**Addendum No. 1**

RE: Contract ID C203403  
WBS # 8CR.10771.20 Etc.  
State Funded

**Richmond County**

1 Section of US-74 EB, 1 Section of NC-177 and 8 Sections  
Of Secondary Roads

DETAIL FOR MAP #2

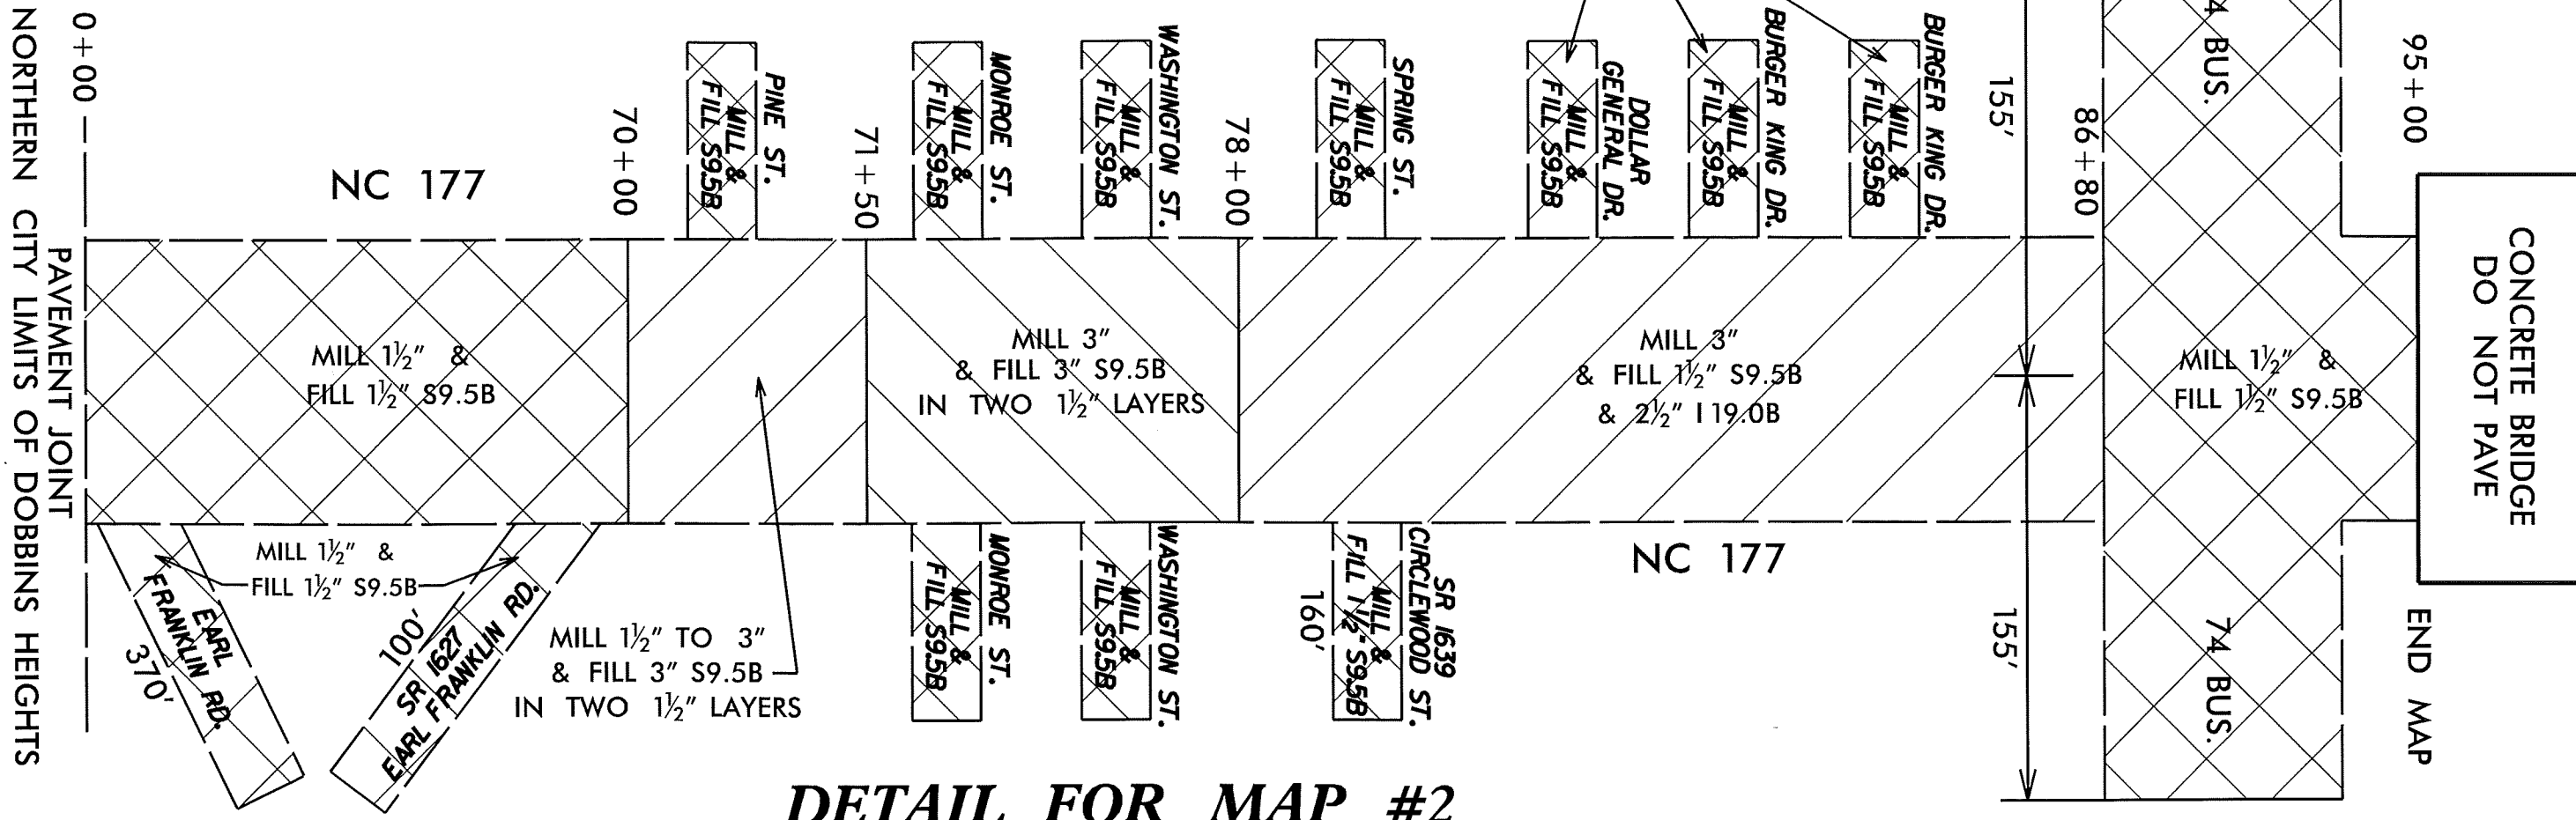
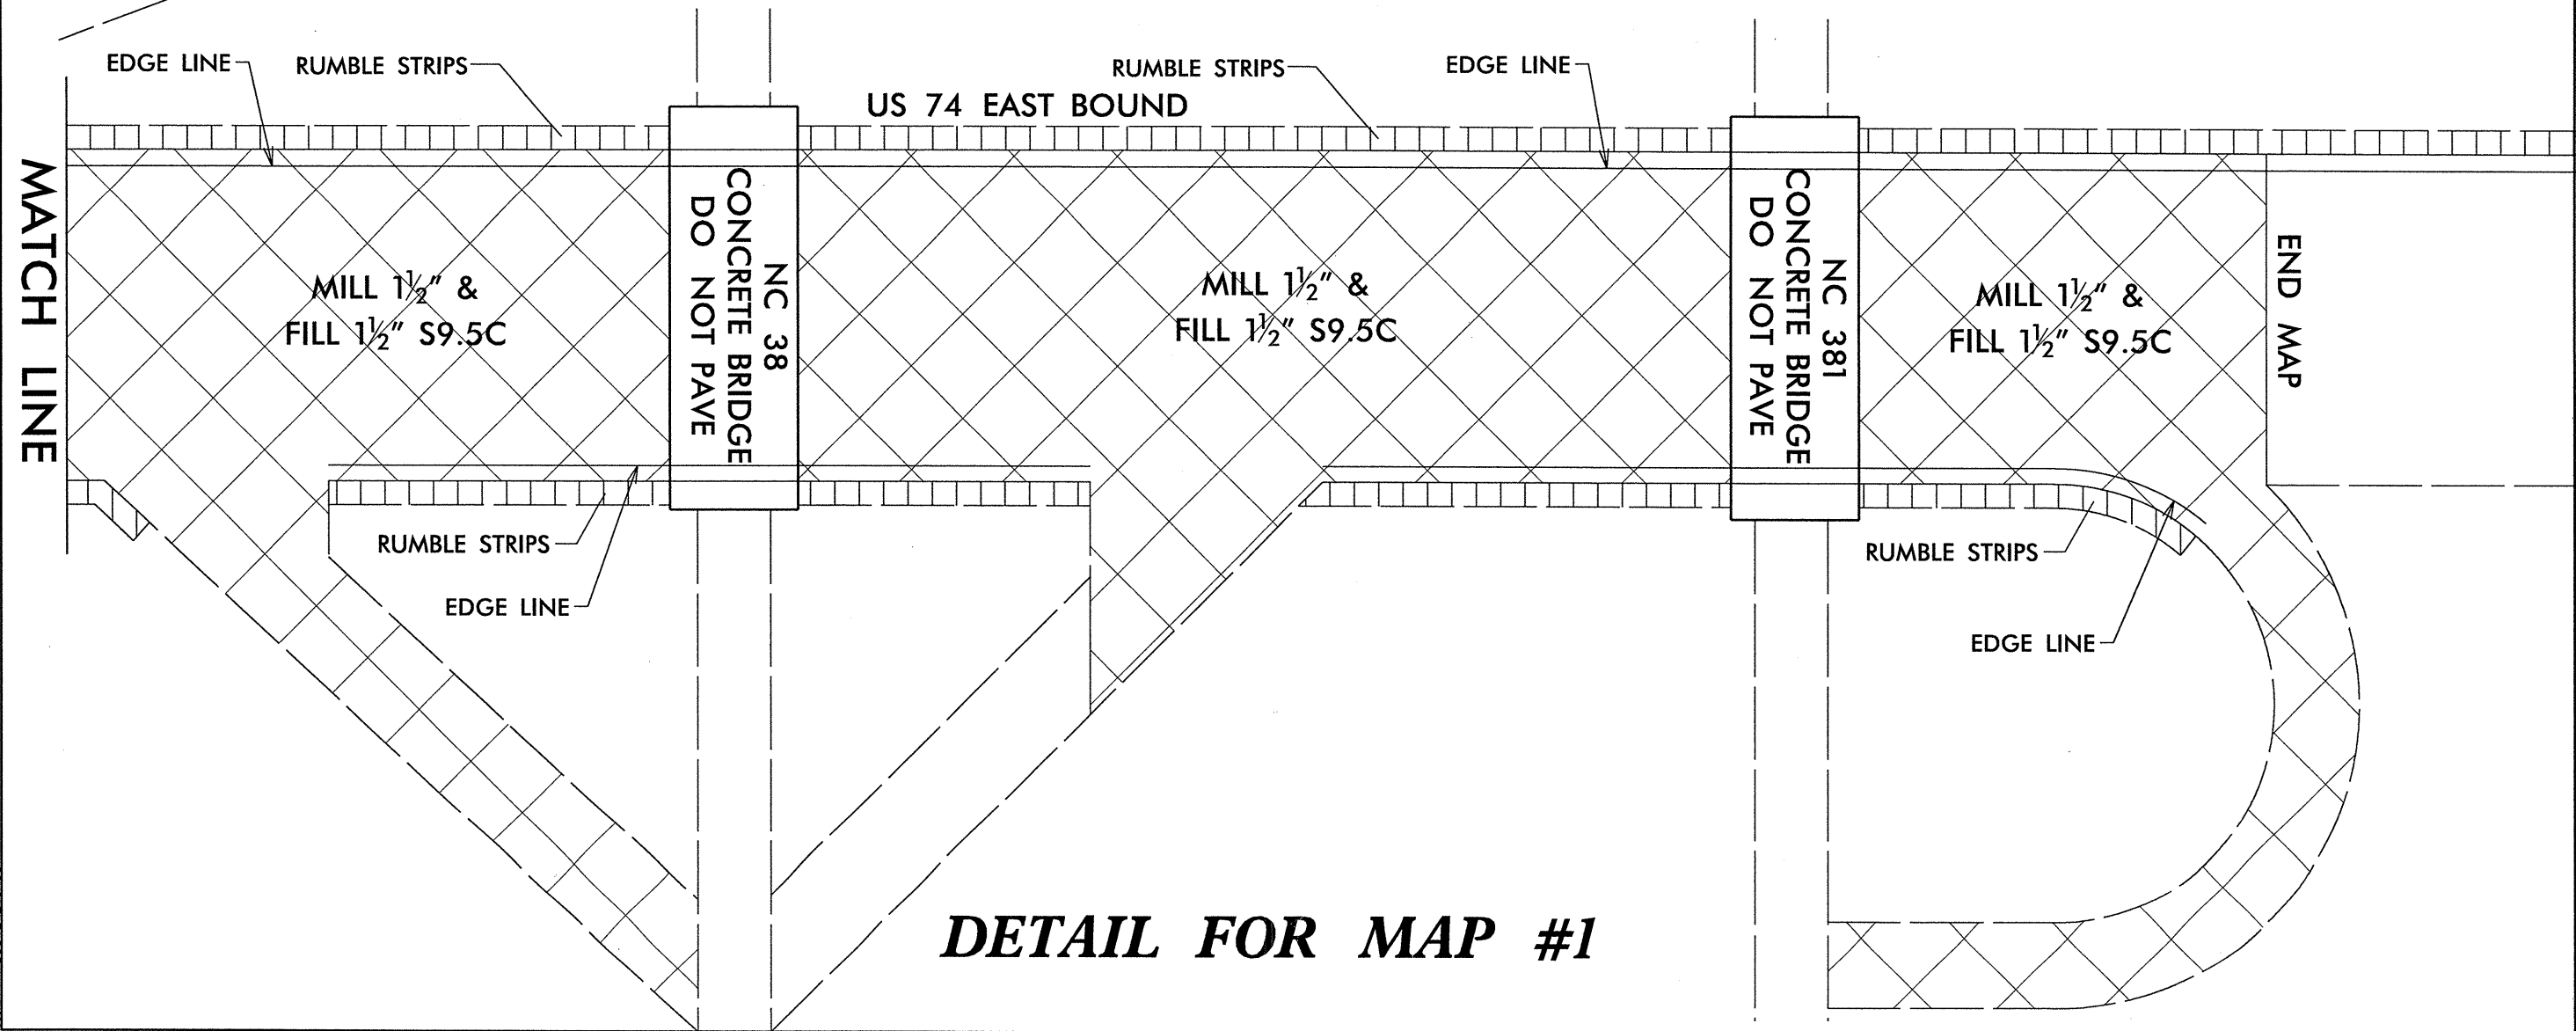
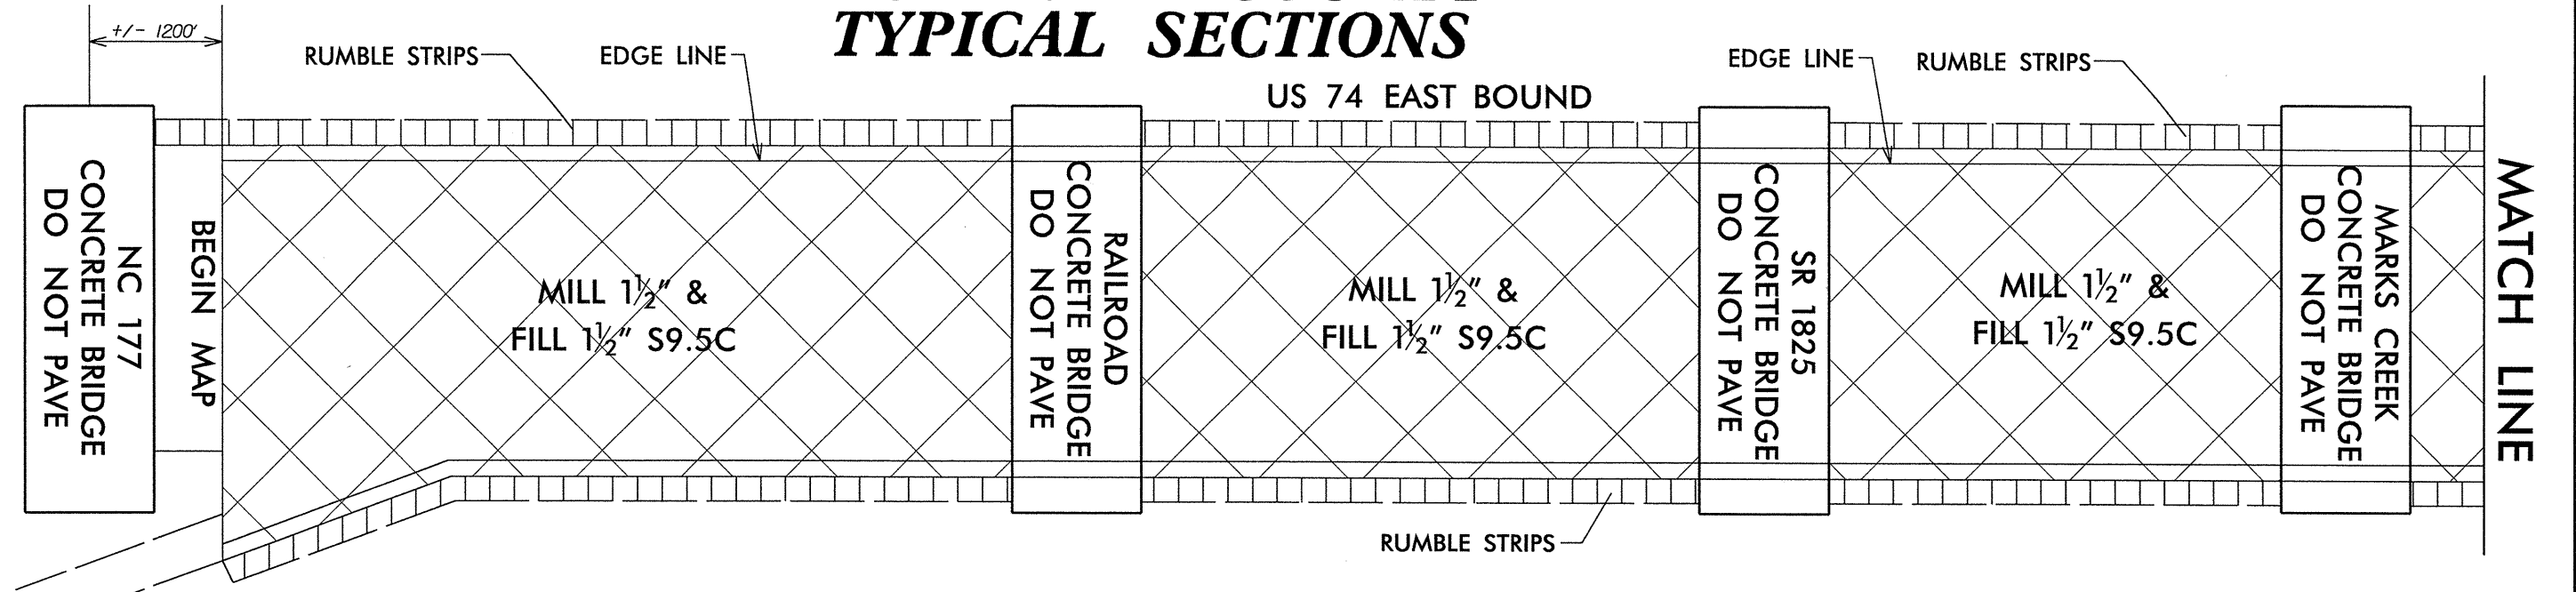
On Sheet No. 6 a note has been added to the "Detail For Map #2" to describe the work to be performed at "Burger King Drive" and "Dollar General Drive". Please void Sheet No. 6 in your plans and staple the revised Sheet No. 6 thereto.
